Submission from the School Community of Sydney Girls High School to the Director, Infrastructure Planning Services.

Subject of submission: Application No SSI 6042 MOD 1 - CSELR Modifications Assessment Report 3rd Dec 2014

Figure 4: Proposed modification to Moore Park stop

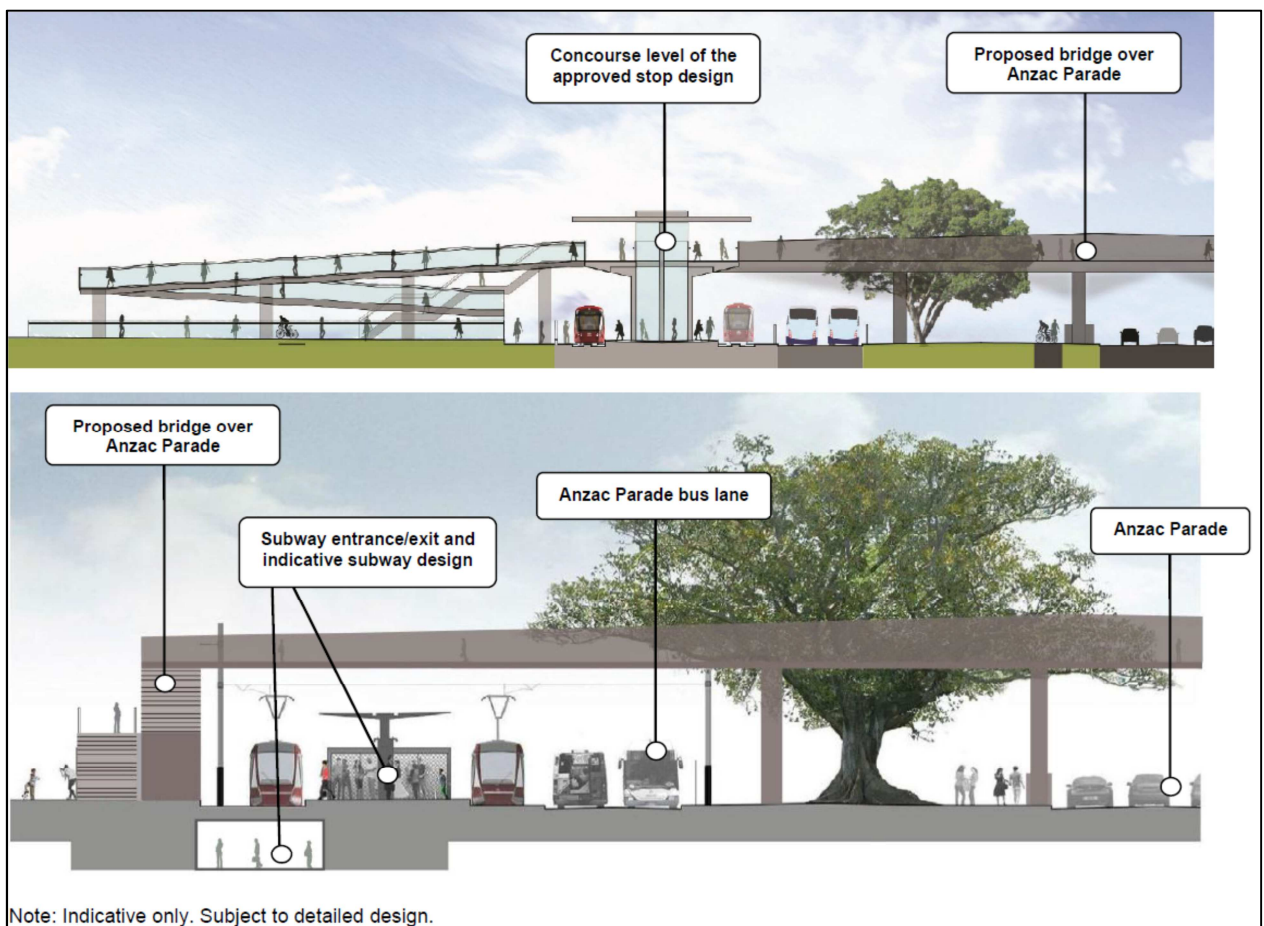
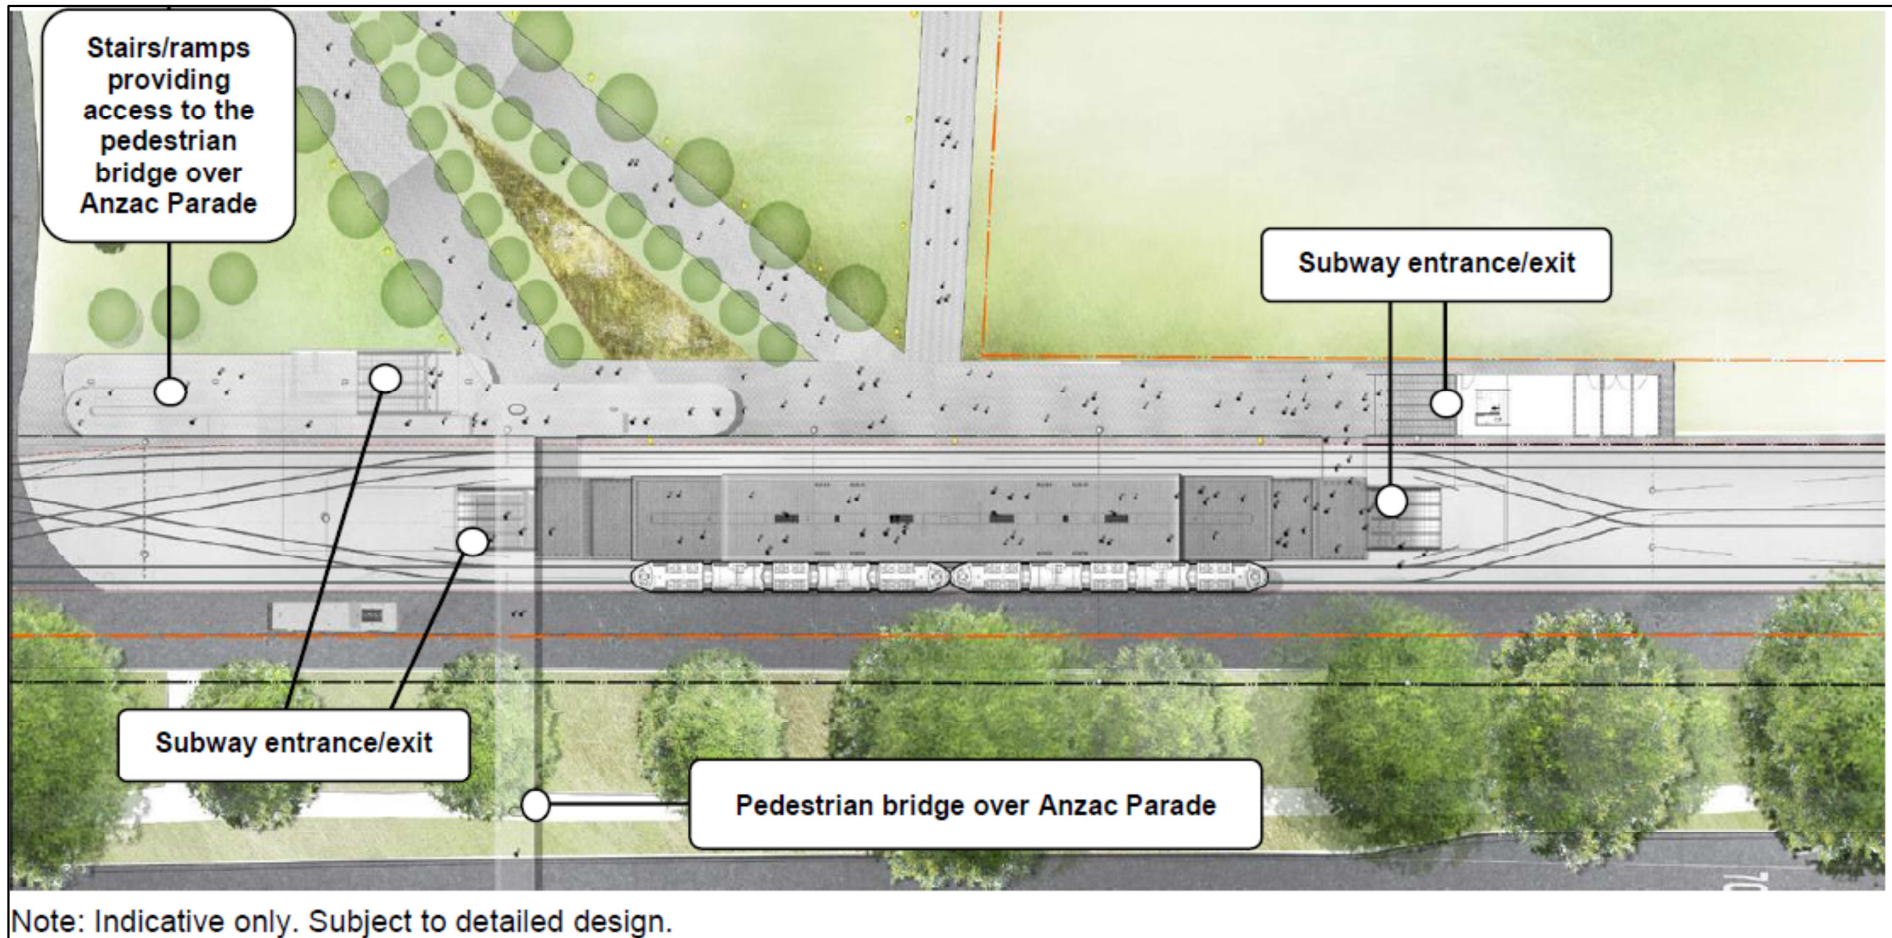
With the change in the Moore Park (MP) LR station from 2 storey to single storey, it is now unclear if there will be a direct connection with the overhead bridge crossing Anzac Pde and joining the MP LR station to Sydney Girls High School (SGHS) and Sydney Boys High School (SBHS).

This may mean school children in both the morning and afternoon peak periods may need to cross a set of tram tracks. At these times, approximately 2000 children will be accessing the LR in a very short space of time, including approx 1500 who will be going to Central Station, crossing tram tracks when multiple trams will need to be leaving the MP station. This surge of school cannot be compared to what will happen at other LR stops as suggested in the modification justification p18 3.5.2 para 3 *“Under normal operation, the MP stop would be accessed via pedestrian crossings over the LR tracks, and access ramps similar to all other stops”*. No other stops along the alignment will have at least two occasions per school day when, over a very short period of time, around 2000 children will cross tram tracks unsupervised.

As far as can be ascertained from the modifications document there will be no additional safeguards in place for school children to cross tram tracks compared to the additional safeguards dealing with crowds emerging from sporting events i.e. for these special events there will be: (1) Underground subways opened to the public to avoid the crossing of tram tracks and, (2) Additional LR staff will supervise the public's access to the MP station.

1. That the new pedestrian overbridge across Anzac Parades is designed to allow students to access the LR platform directly, doing away with the need for children crossing any tracks at all. Given the considerable expense involved in the design and construction of the pedestrian bridge, it would seem sensible that it is designed with this feature in mind. **This is our preference for safety reasons.**
2. Otherwise, the track crossing will need to be staffed by the operator and the subway platform access open every morning and afternoon of the school year (similar to a large event).
3. We seek assurance on the capability of the reconfigured and less frequent service to transfer approx 1500 students efficiently to and from central station each and every morning and afternoon within 15-30 minute period.
